# OBJECTION

No. 3 Manor Road  
Hatfield  
Herts AL10 9LN

**Application Reference 6/2021/3320/VAR**  
**Variation of Condition 18 (revised layout) on planning permission 6/2019/2752/VAR**

Drawing Title: Proposed Elevations 1 of 2

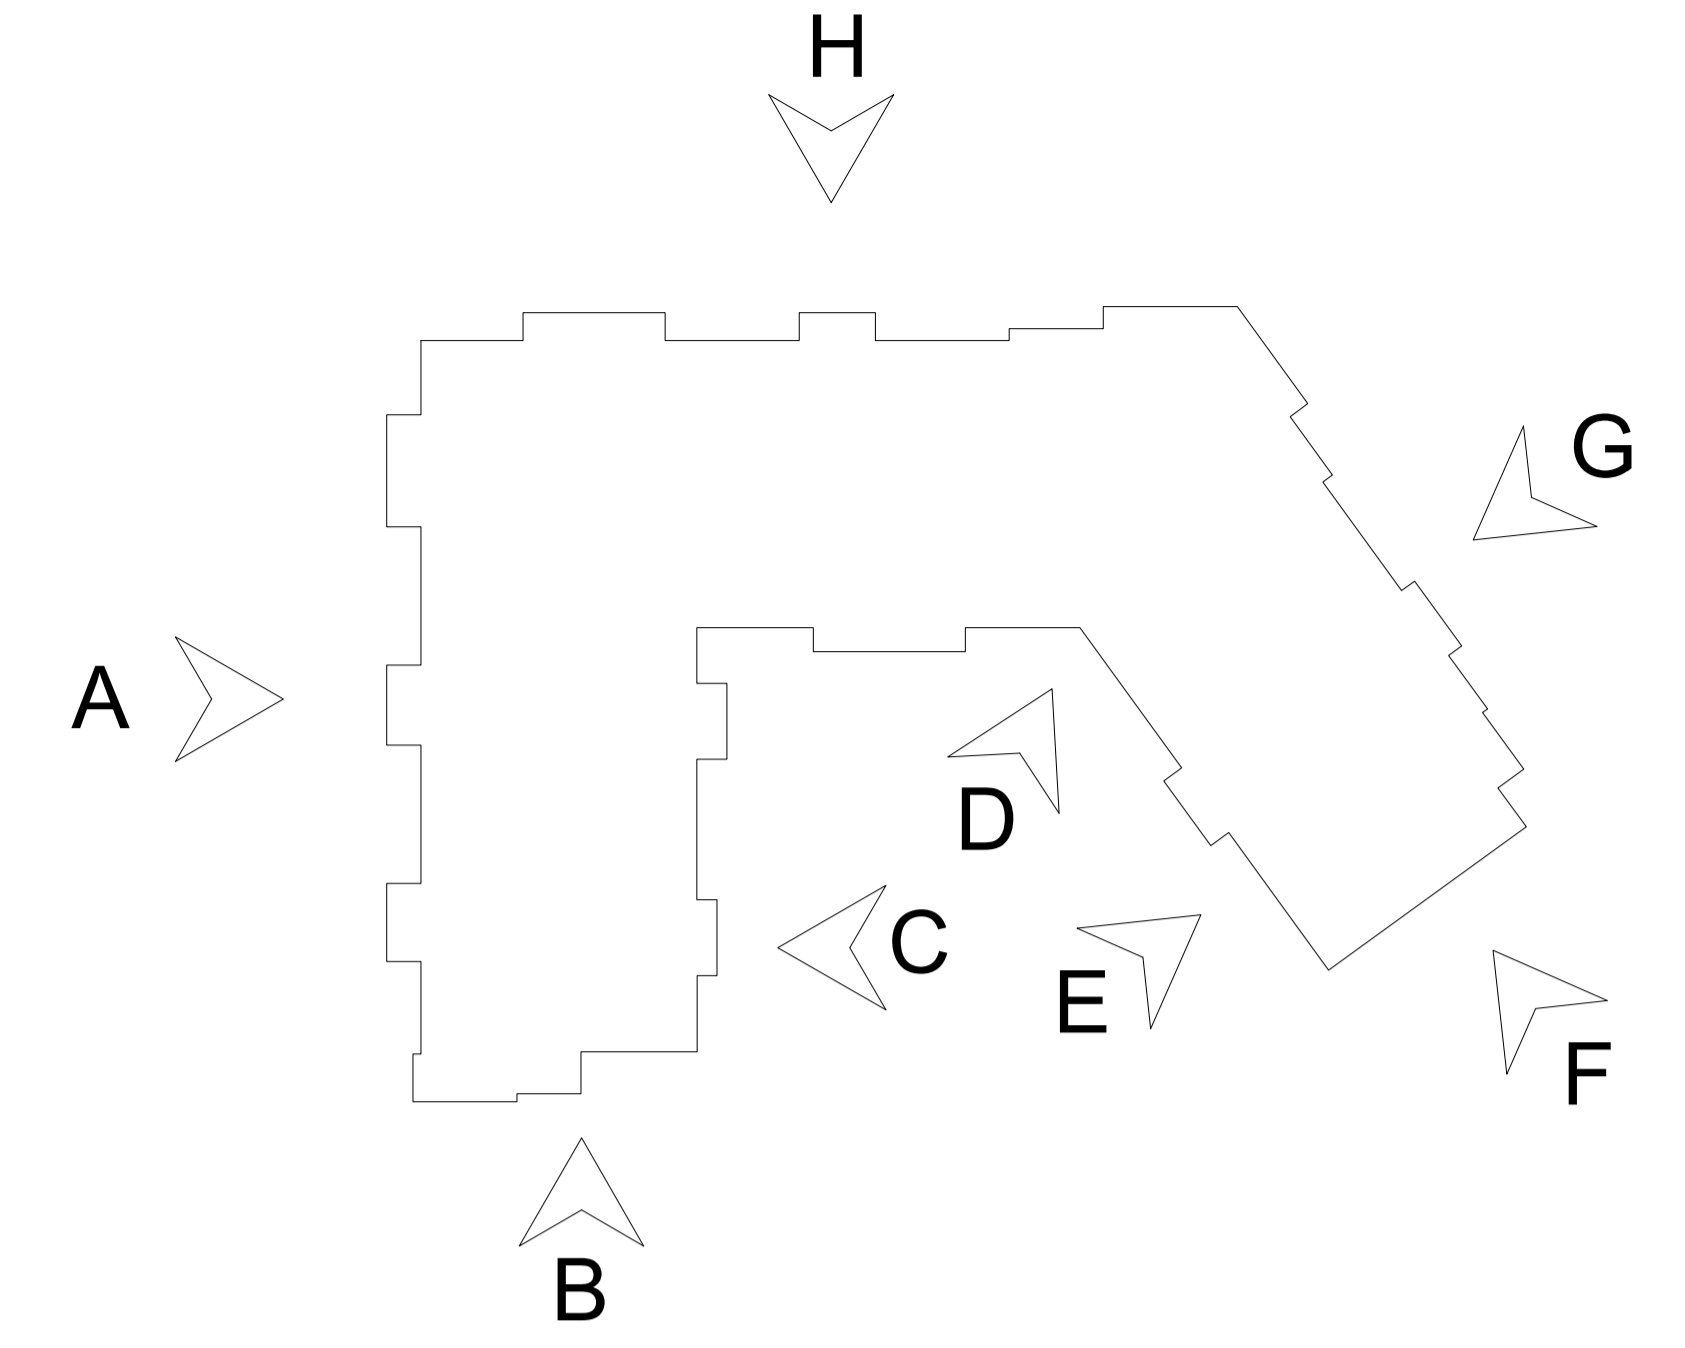
As per our last objection dated 14 October 2021, we are writing again, with renewed frustration, to register our objections to the above variation submitted on 16<sup>th</sup> November 2021, to the building work taking place on Manor Road, which has moved Tank Room, Plant Room, Laundry and kitchens to the North elevation.

- Plant Room on North Elevation facing Manor Road
- Main Kitchen on first floor North Elevation facing Manor Road
- Laundry Room on Ground Floor North Elevation facing Manor Road
